Application no: 21/02376/DISC

Location: E P Barrus Ltd, Launton Road, Bicester, OX26 4UR

Lead Local Flood Authority

Objection to discharge condition 6.

Drawn By:	RS	Client	Markbank Construction Ltd.
Chkd By:	WRA	Project	Proposed Redevelopment, Morley Site, Arkwright Road, Bicester
Scale @A3:	1:500	Title	Impermeable Area Plan
Date:	08.07.2021		
Status:	TENDER		
Project No.:	23200	Drawing No:	E13
		Rev:	B

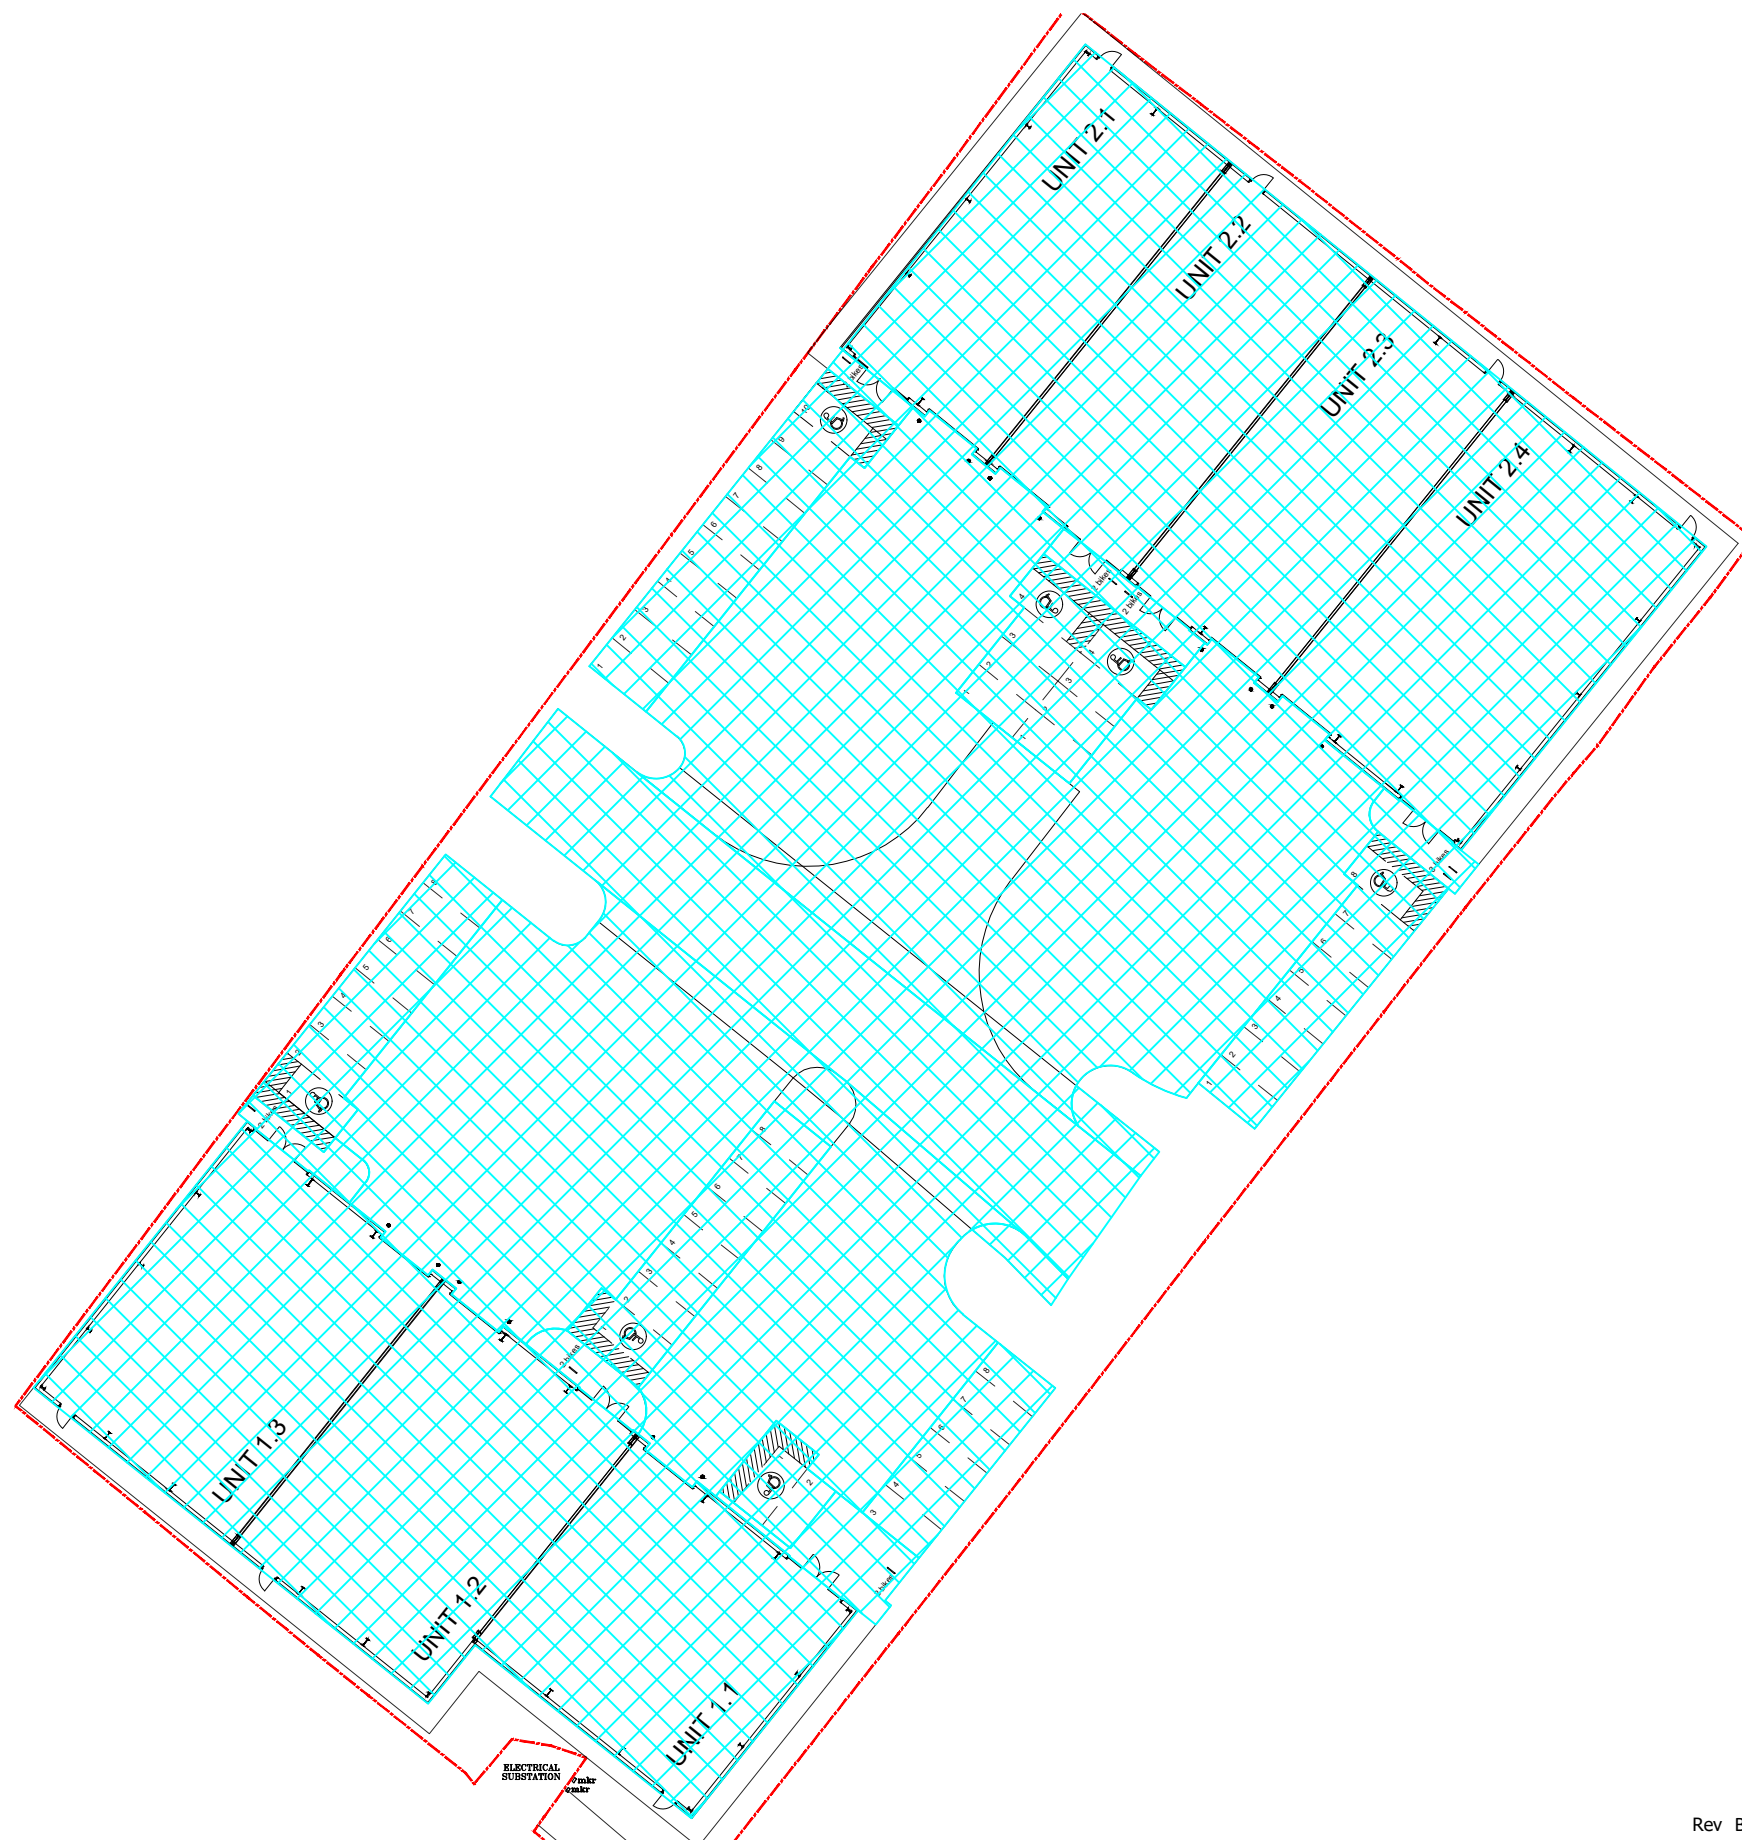
Calculations should include all SuDS features and drainage infrastructure. Calculations for the permeable paving to be provided. The impermeable area used in the calculations do not match the impermeable area on the surface water catchment plan.

<table><tr><td>Drawn By:</td><td>RS</td><td>Client:</td><td>Markbank Construction Ltd</td></tr><tr><td>Scale @ A0:</td><td>1:200</td><td>Title:</td><td>Proposed Drainage Layout</td></tr></table>

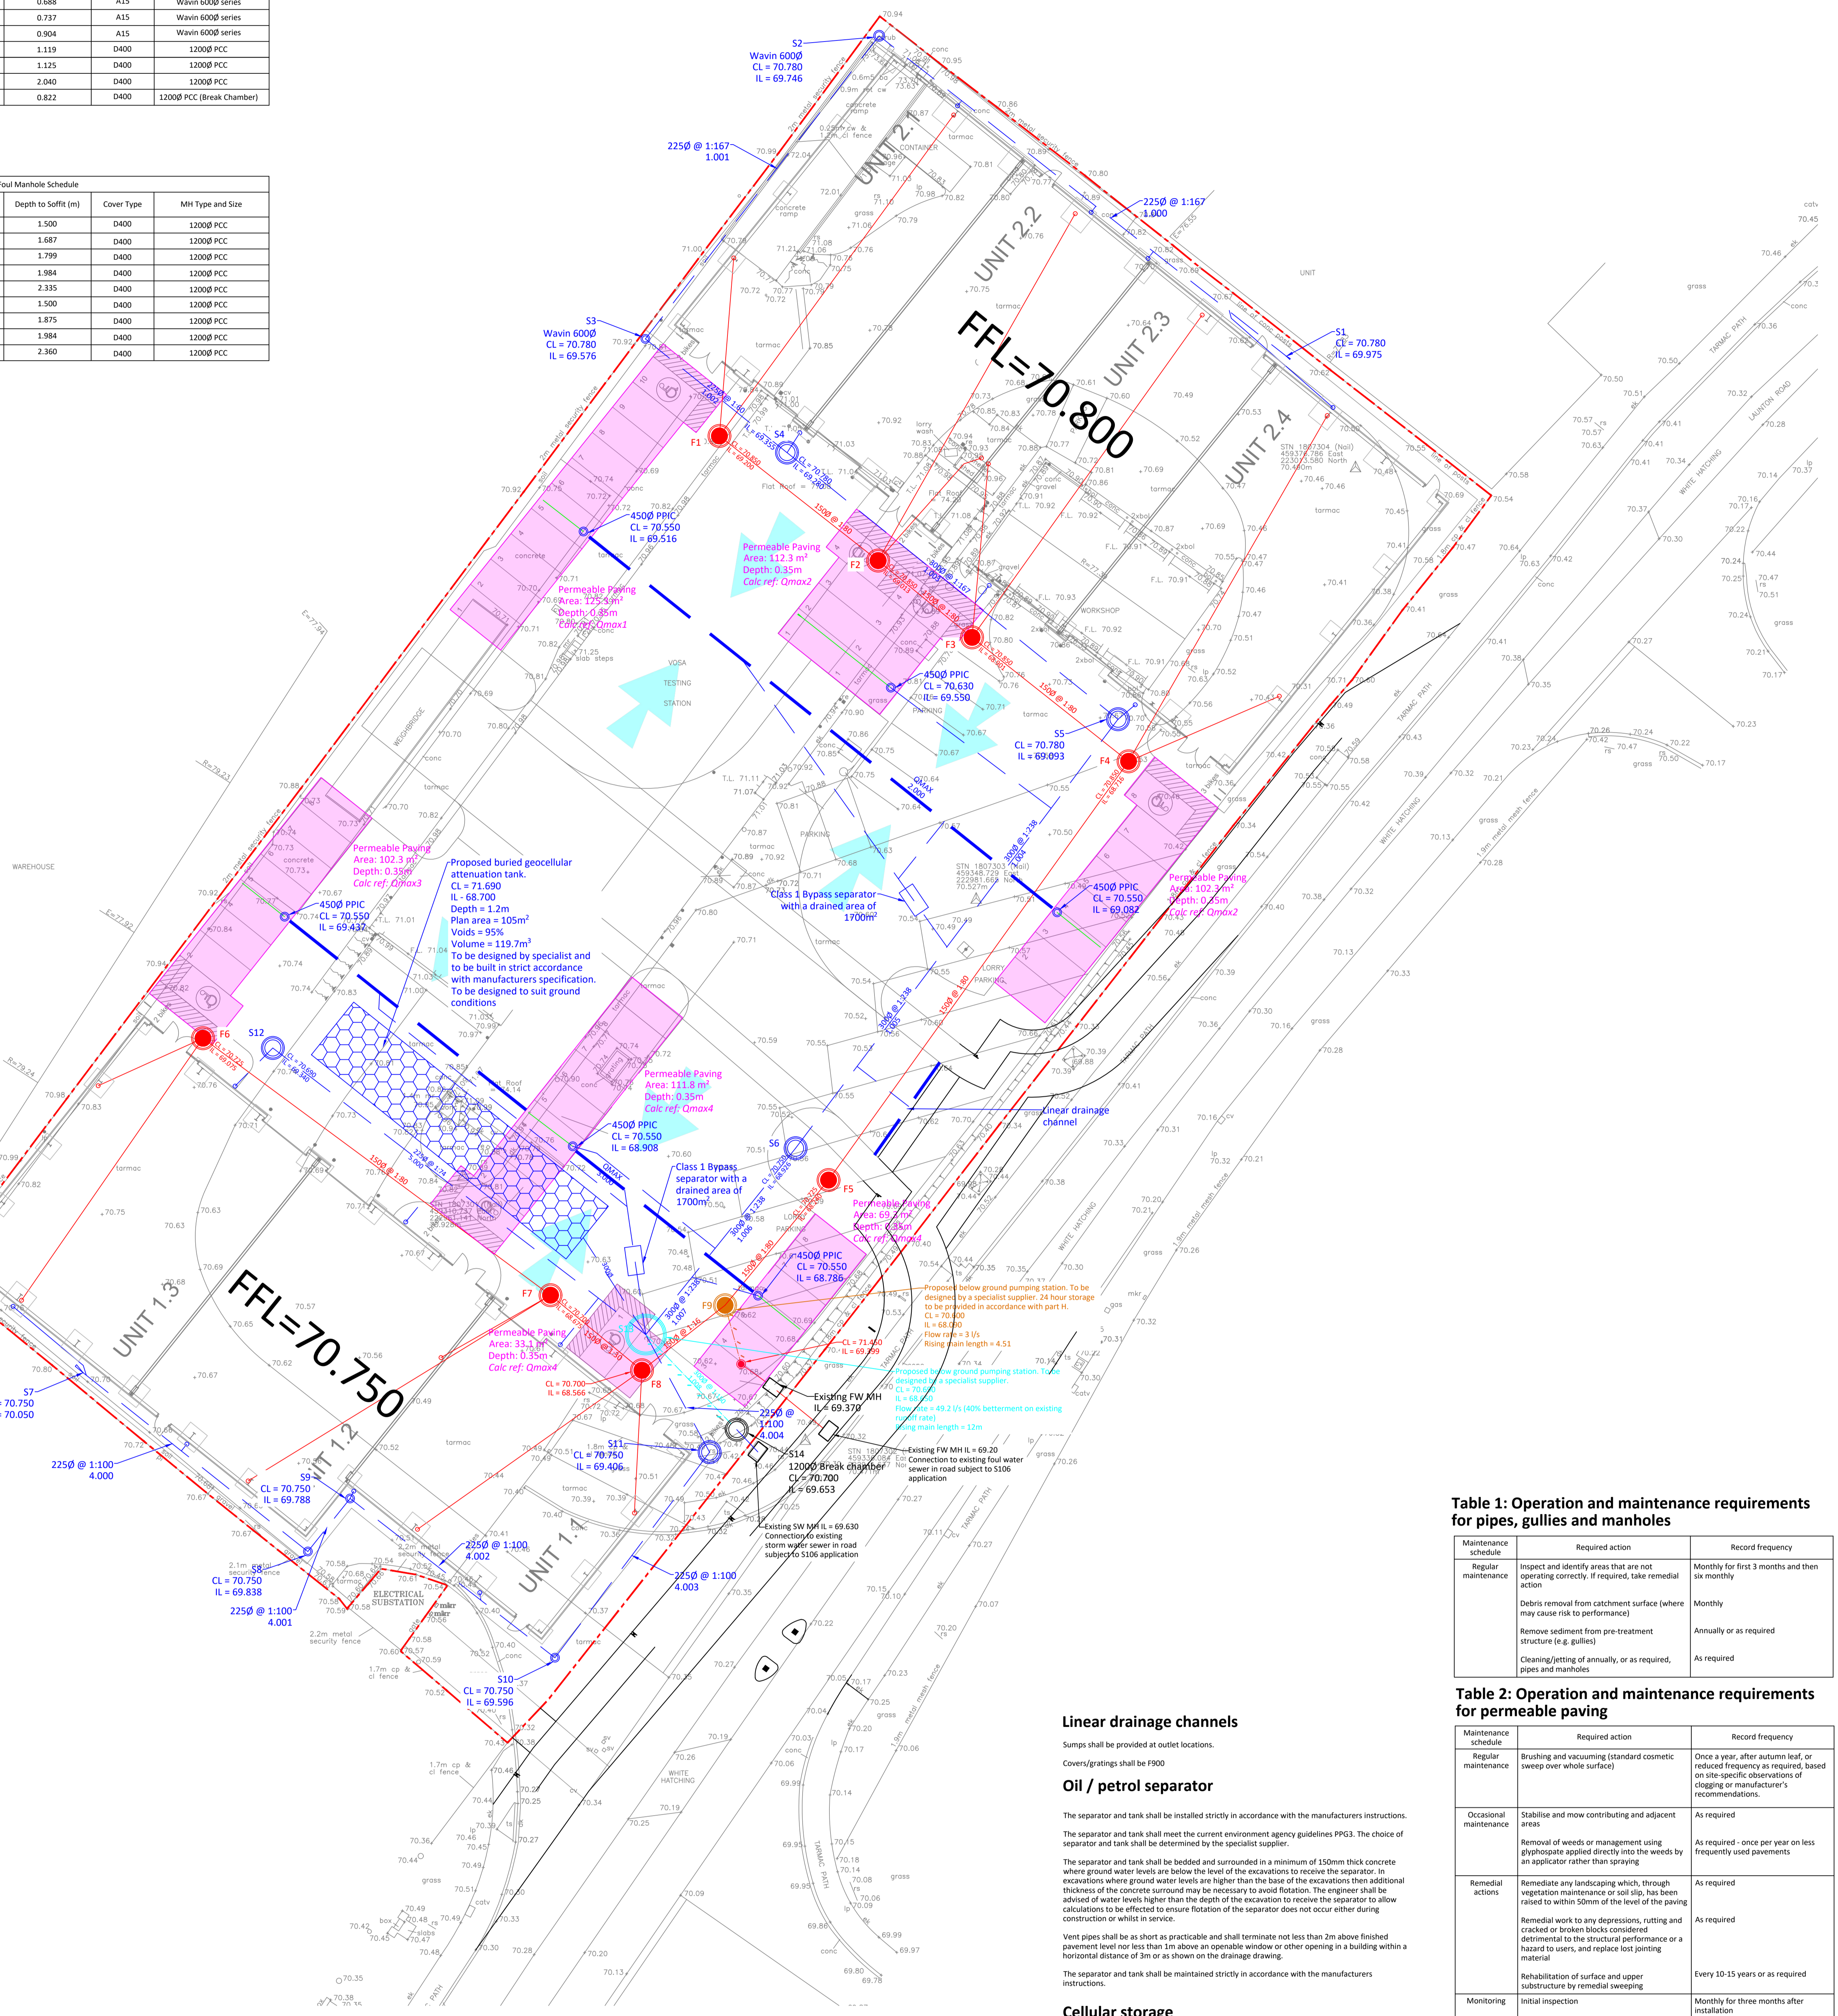
Drainage strategy drawing to be detailed. permeable paving area and sub base depth to be provided for each section of permeable paving. Storage tank does not show it being connected to the surface water network. Please clarify how the storage

tank is linked to the surface water network on the plan drawing. Pipe number 1.006 can't be found on the drainage plan. Please clarify what the thick blue polyline represents connecting the permeable paving.
